PLAN REVIEW SHEET

Date: January 26, 2023

Petition #: RZP 2022-147

Address: 6100 Fairview Rd.

RZ-101

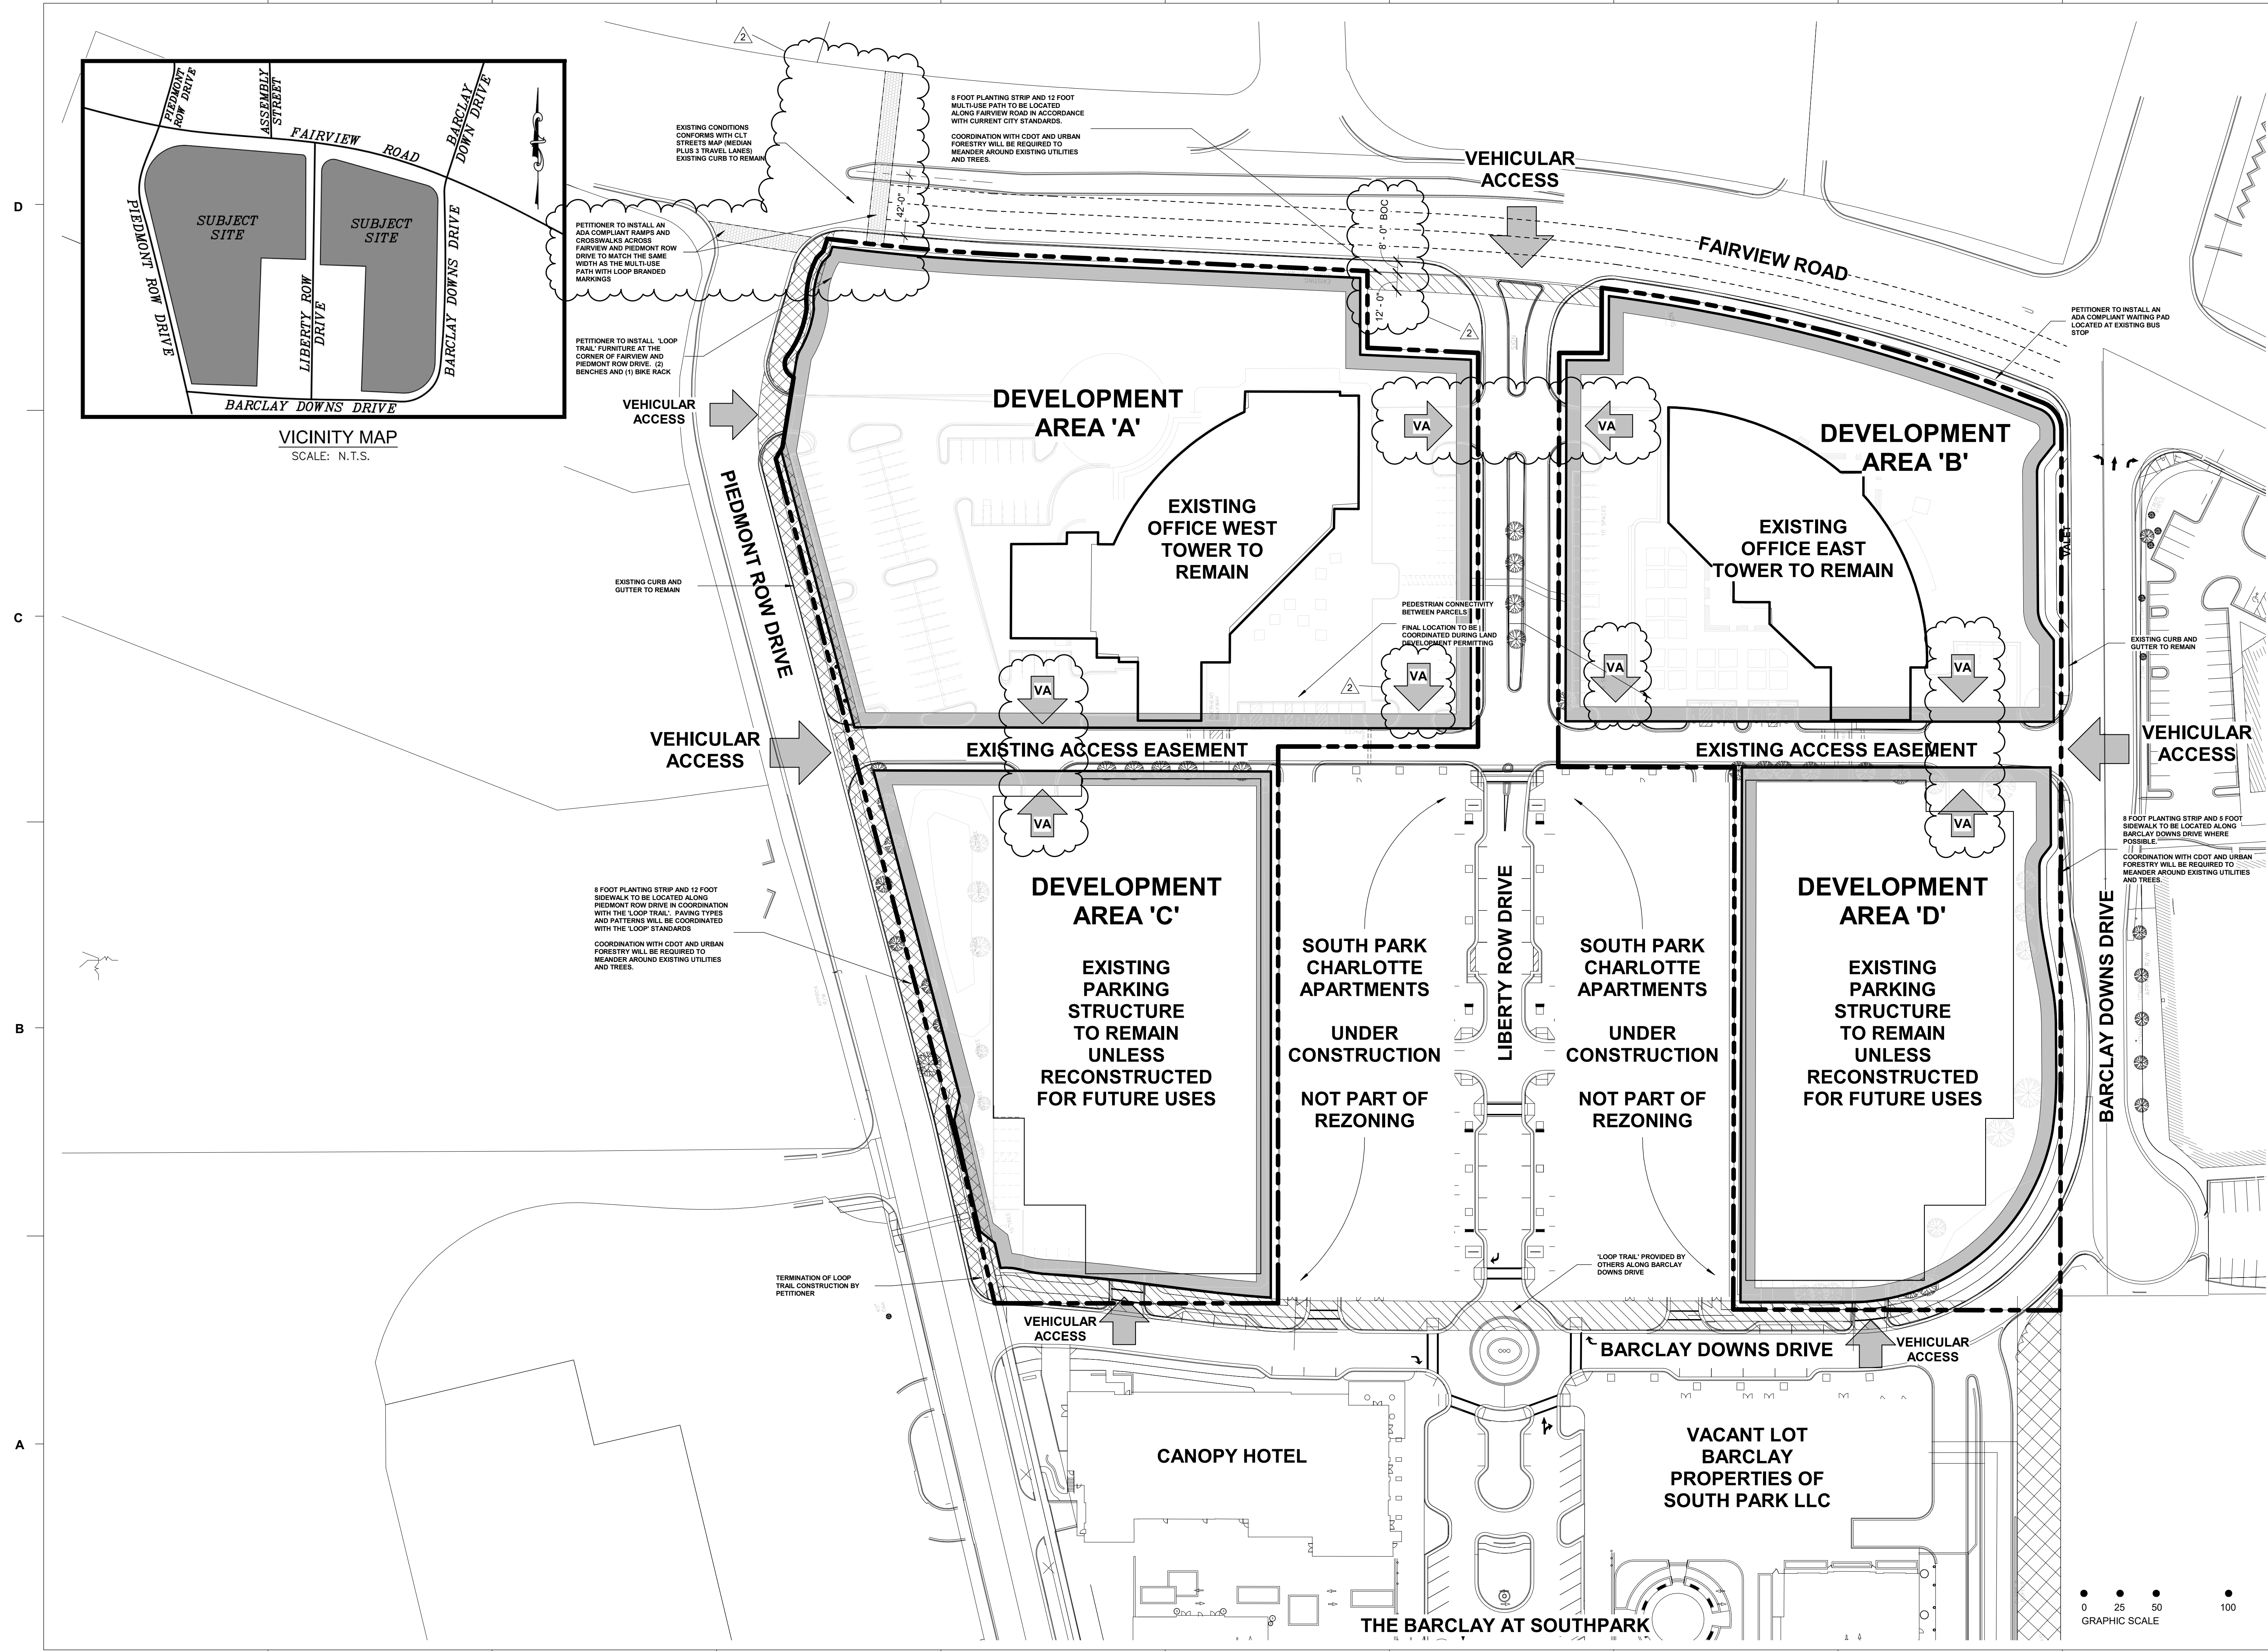
The site is located along CATS local bus route #19 on Fairview Rd. CATS requests the construction of a new ADA compliant waiting pad per Land Development Standard 60.03A at the current bus stop location.
